**Our Case Number:** ACP-323849-25

**Re:** The proposed development is for a mixed use development that seeks the regeneration and adaptive reuse of a strategic brownfield site, as part of the Limerick City and County Council 'World Class Waterfront revitalisation and transformation project' 'Cleaves Riverside Quarter' in the townland of Farranshone More in Limerick City.

Ref: ACP-323849-25

I am writing to request you seriously review the Masterplan being submitted for the Cleaves Riverside Quarter in Limerick city and to request the Architects submit revised plans with solutions. With such a large investment, it is crucial to take the necessary steps to ensure the city's heritage and aesthetic is maintained and not destroyed. Limerick City has a beautiful Georgian centre (sadly neglected) plus medieval quarters and a rich mix of architectural styles mostly built on a pleasing human scale, which is why we love our city.

STUDENT HOUSING / QUARRY WALL BAT HOUSE ELEVATION- 1:50 @ A1

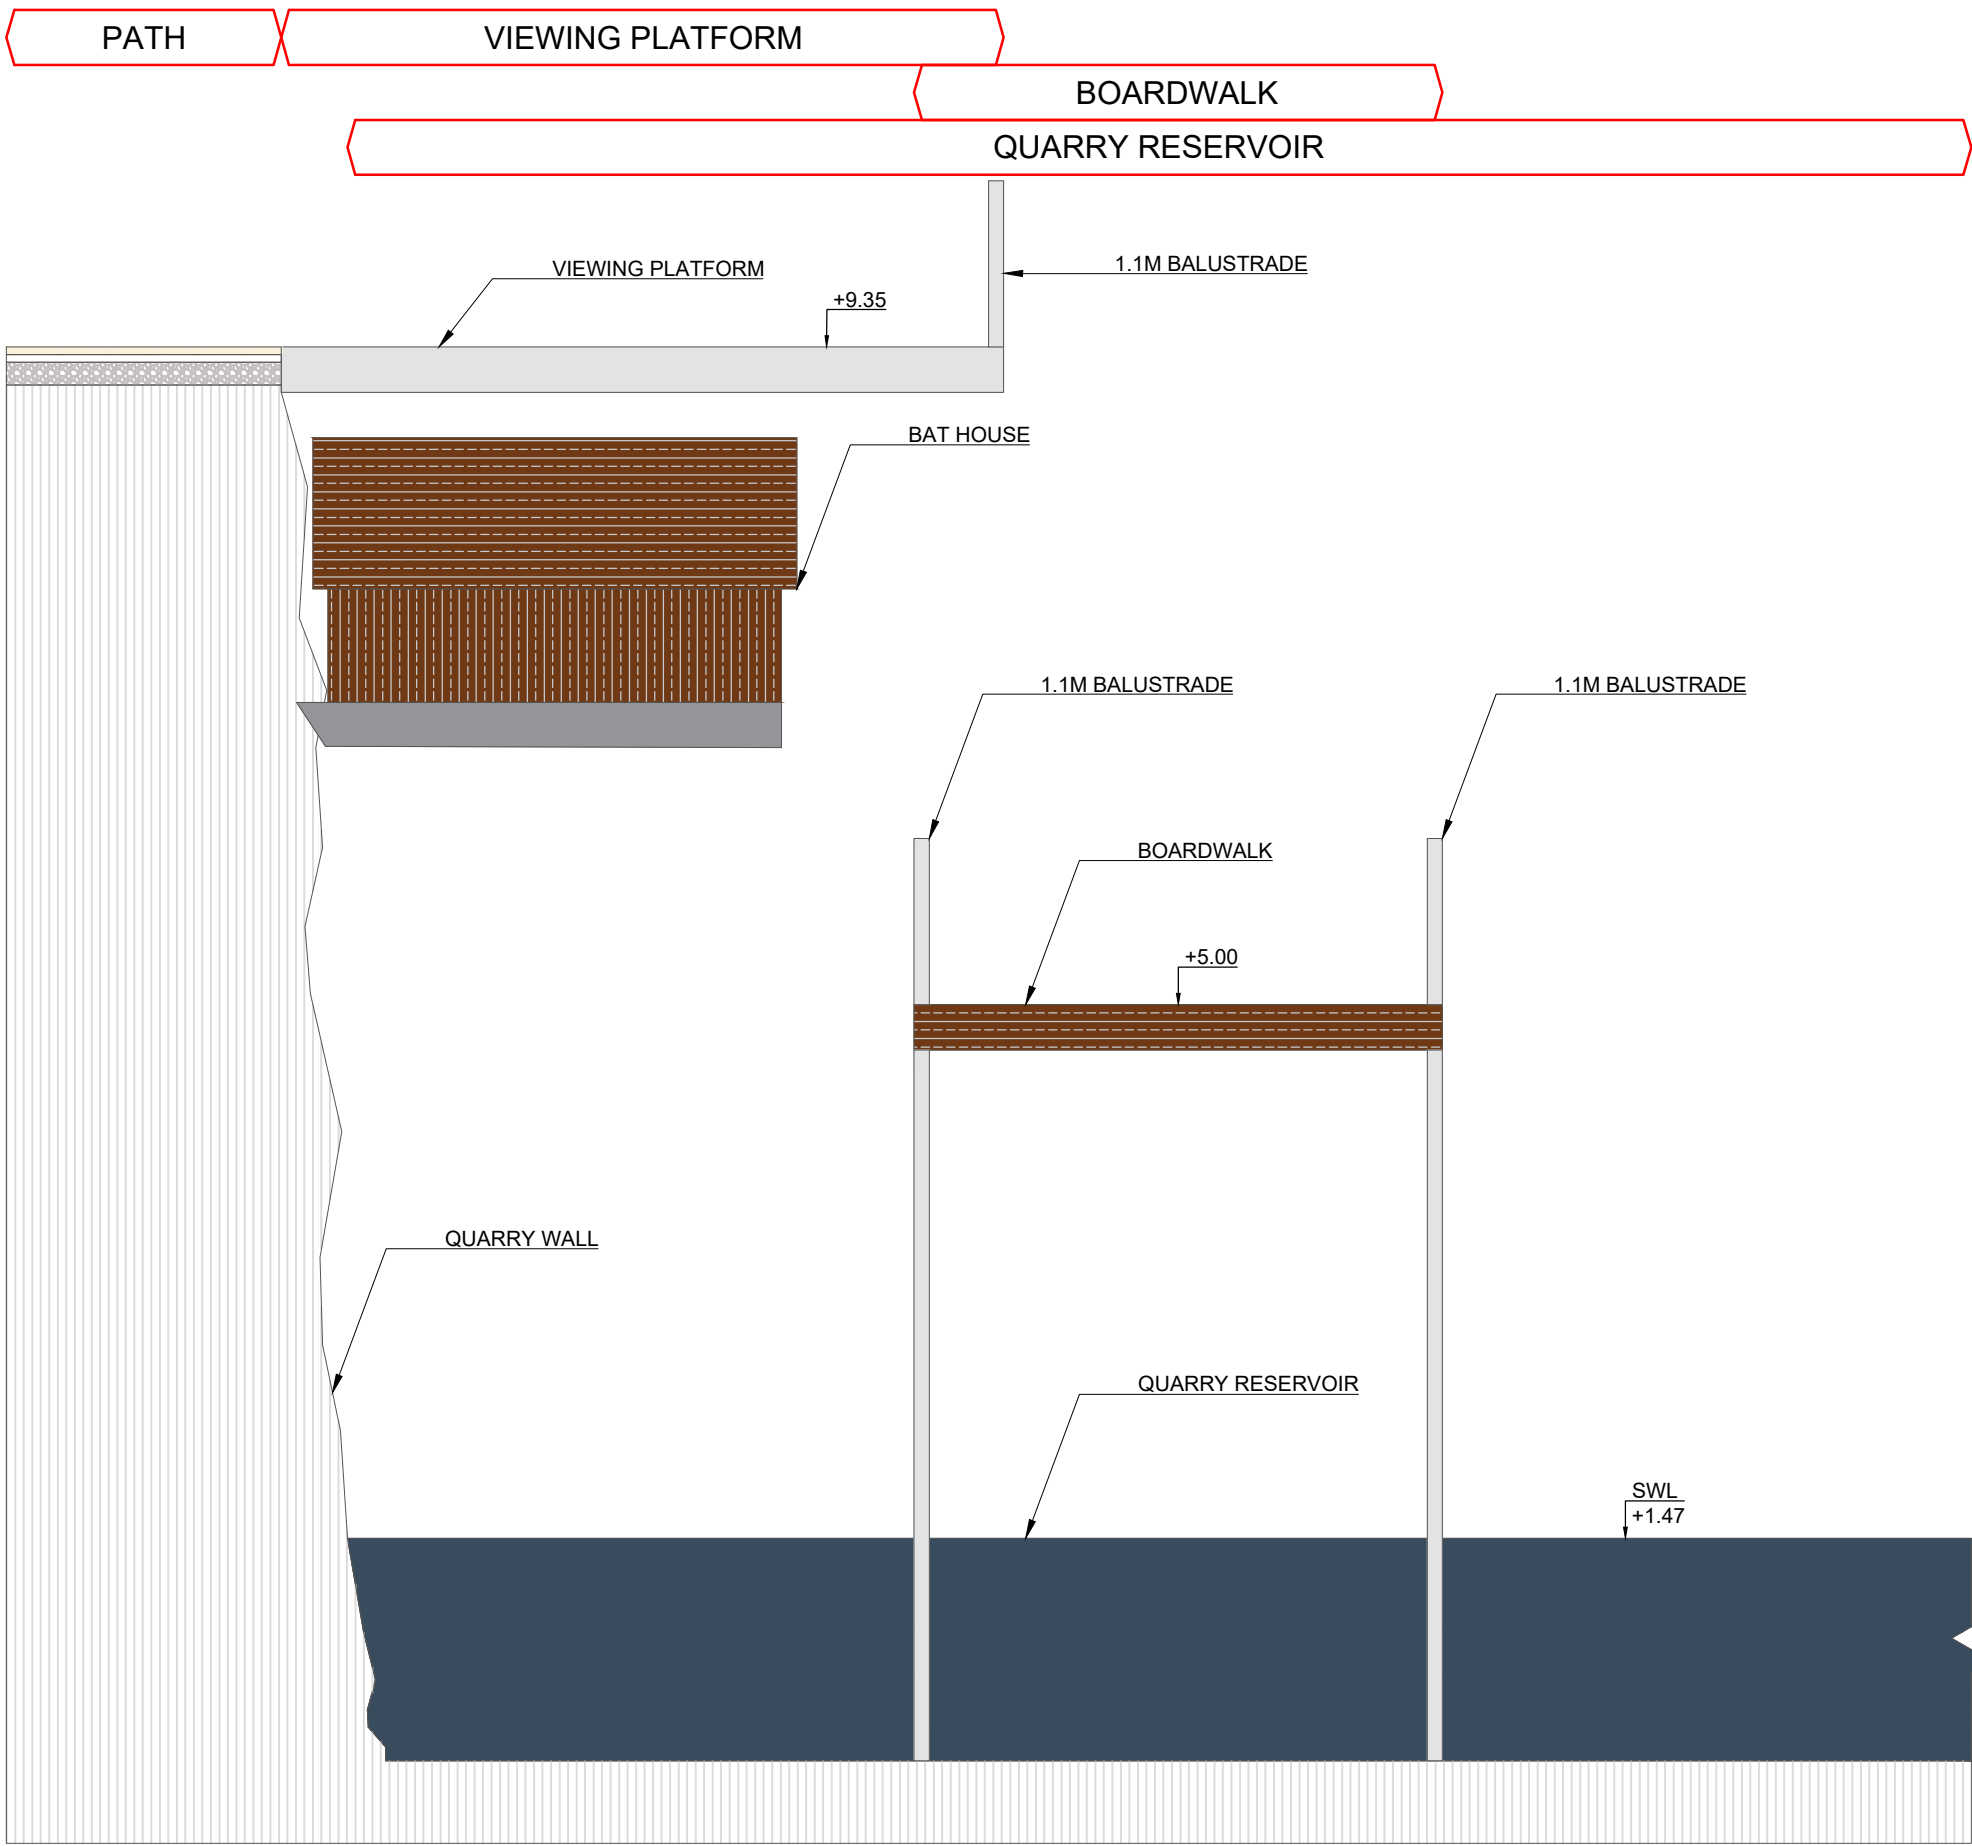
6 – Why is there a plan to build a Bat House? If there are bats on site which are protected, can these be moved to a country location? Will this Bat House not be a health hazard for the residents of the 500 homes onsite?
